Liberty Tree Academy
P O Box 64614
Colorado Springs, CO 80962

June 4, 2018

RE: U-18-001, Approval of Location of Liberty Tree Academy Charter School

LIBERTY TREE ACADEMY			
TOWN OF PEYTON, EL PASO COUNTY CONSTRUCTION DOCUMENTS			
SITE PLAN			
DESIGNED BY: ACR	SCALE	DATE ISSUED: MAY 2018	DRAWING No.
DRAWN BY: ACR	HORIZ	SHEET 4 OF 18	SP01
CHECKED BY: DRK	VERT.

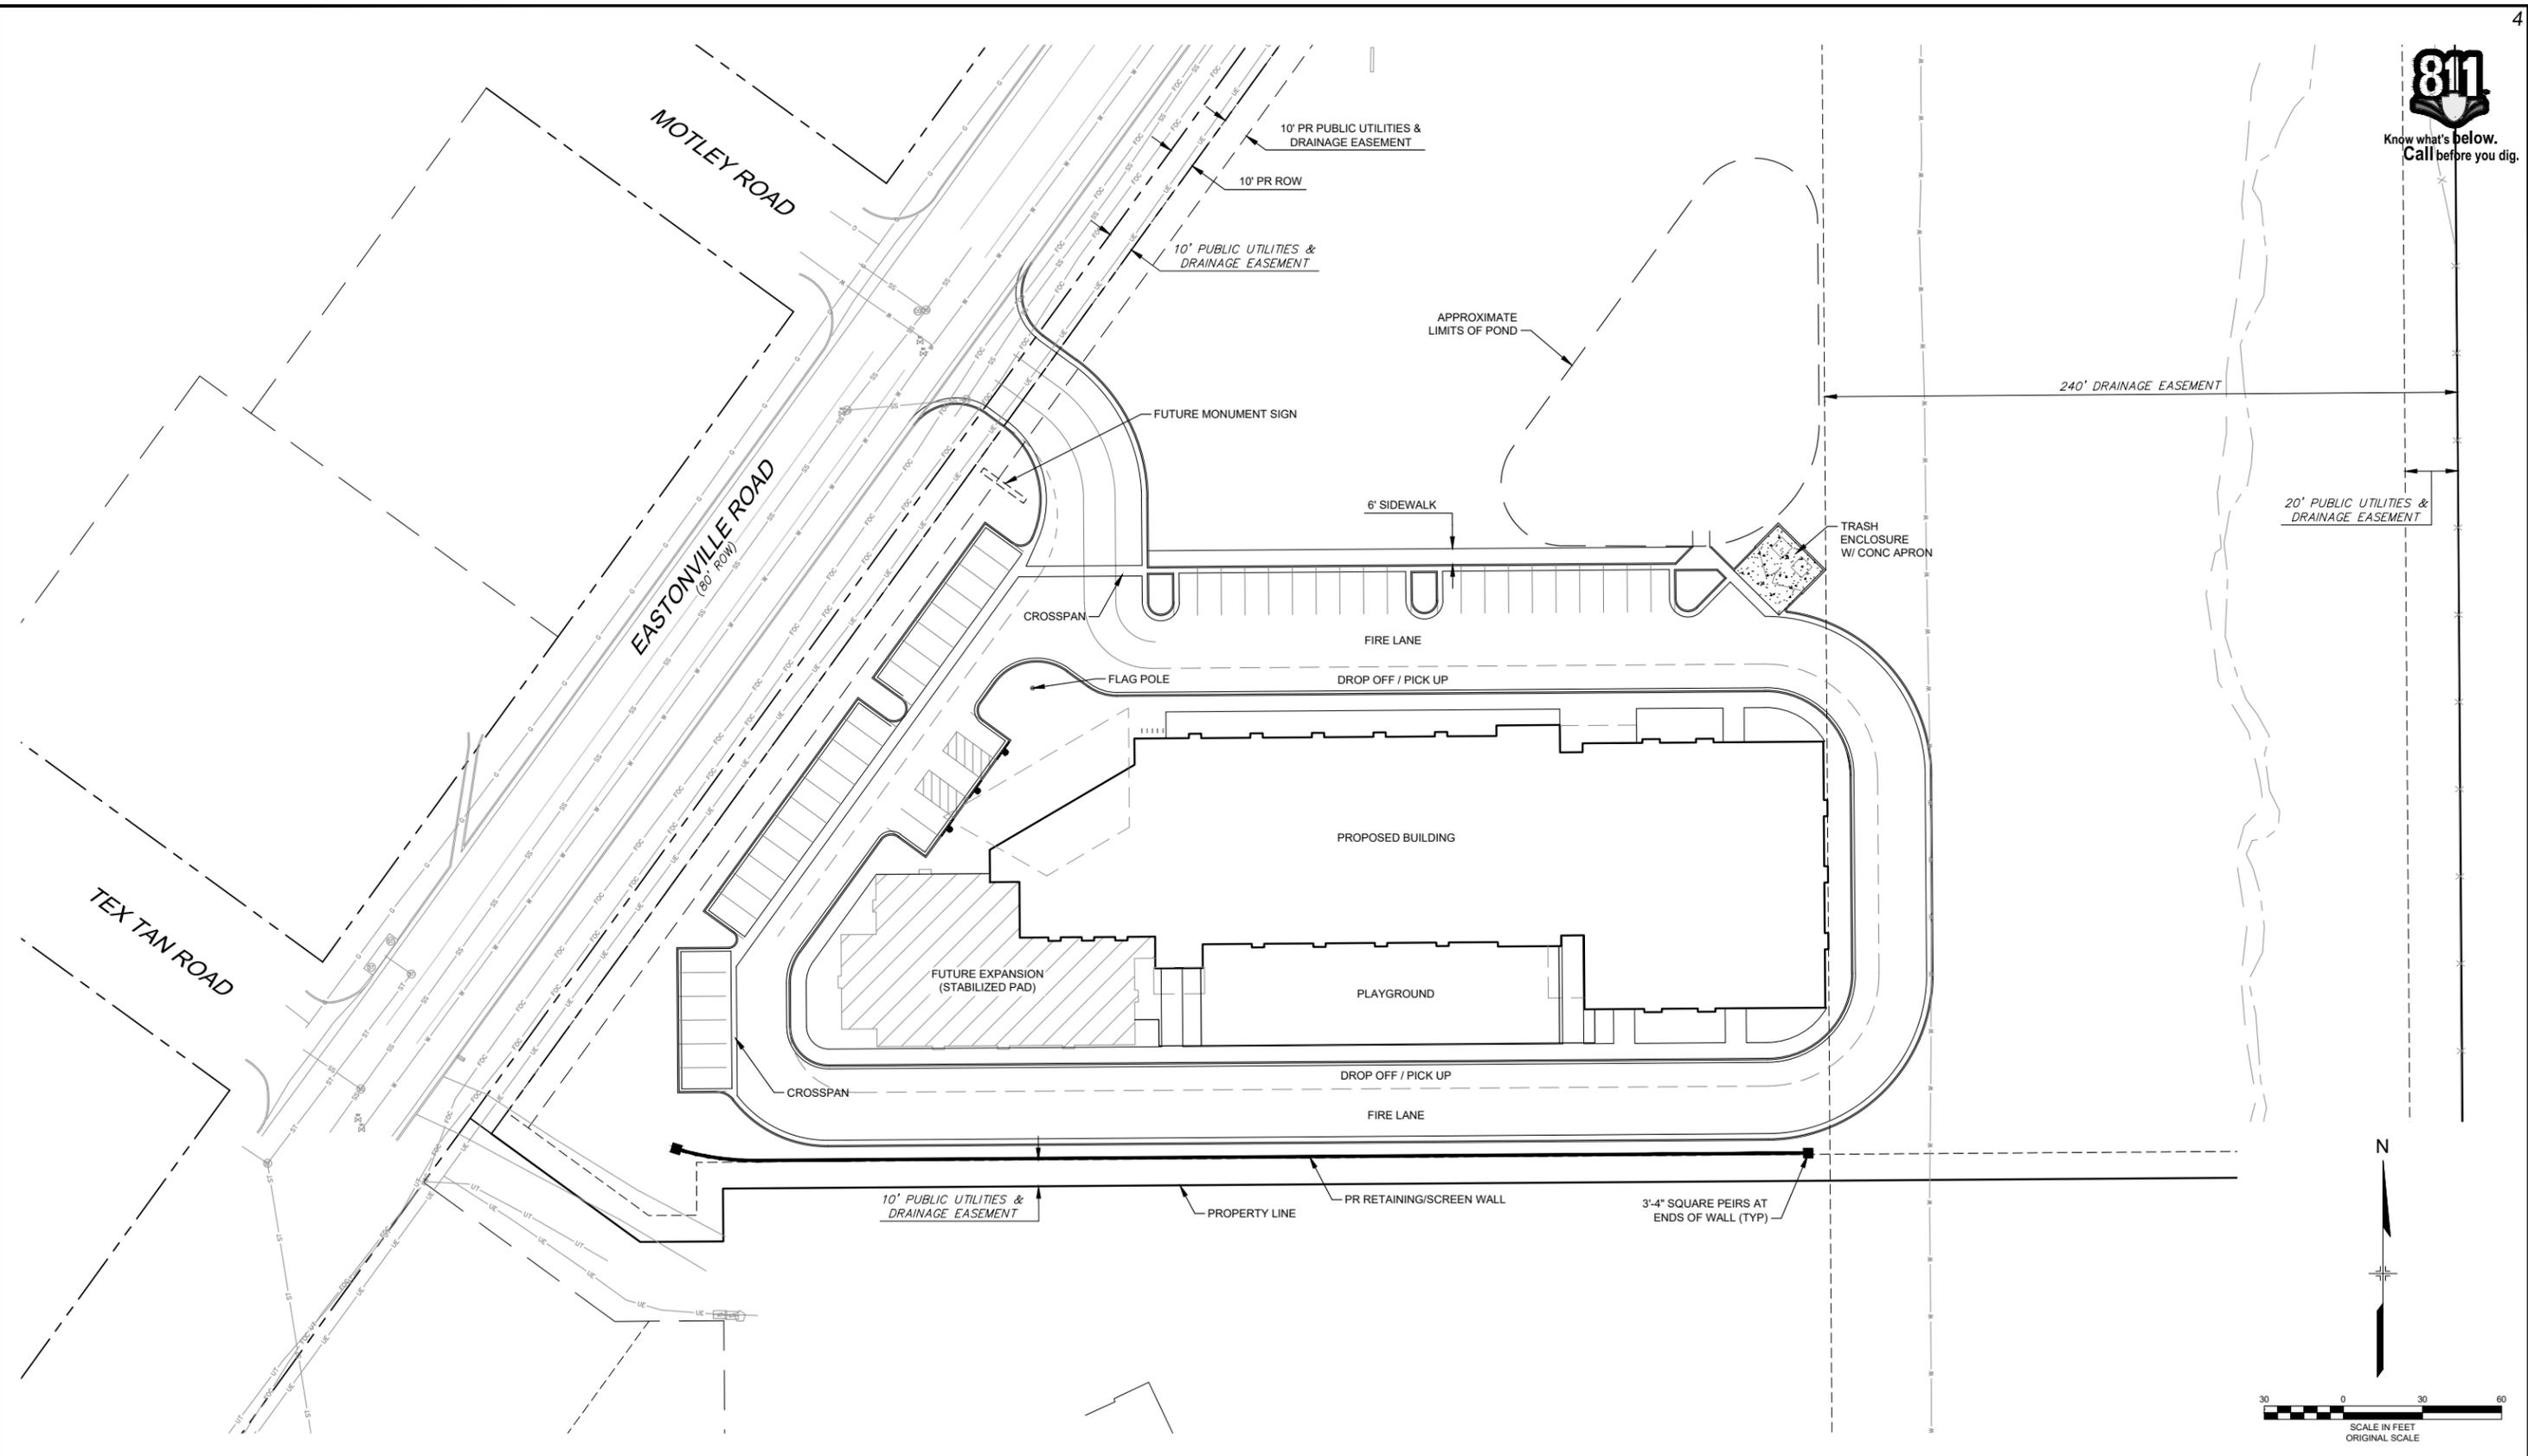
- a. **Adequate vehicle capacity during peak school vehicle periods:** *An internal circulation plan has been proposed utilizing:*
 1. *Appropriate queue lengths as required to be met by code (See Exhibit 2 attached)*

- 2. Sufficient onsite parking during peak periods for school staff and volunteers, parents dropping off and picking up students, and for school event parking. Note: High school students will likely drive and park their own vehicles.**

- 4. Adequate access and parking for emergency vehicles.**

- 5. Should vehicle parking be allowed along Eastonville Road right-of-way. How will this be enforced?**

Onsite parking for employees, parents, students and emergency vehicles are all in accordance with code requirements as drawn on the plans

Code requires that the plan meet Fire truck turning radii which also accommodate buses (which have a similar turning radius). Code will be met per submittal.

There is no parking on Eastonville contemplated.

Sheet SP1.0 Architectural Site Plan shows the drop off lanes.
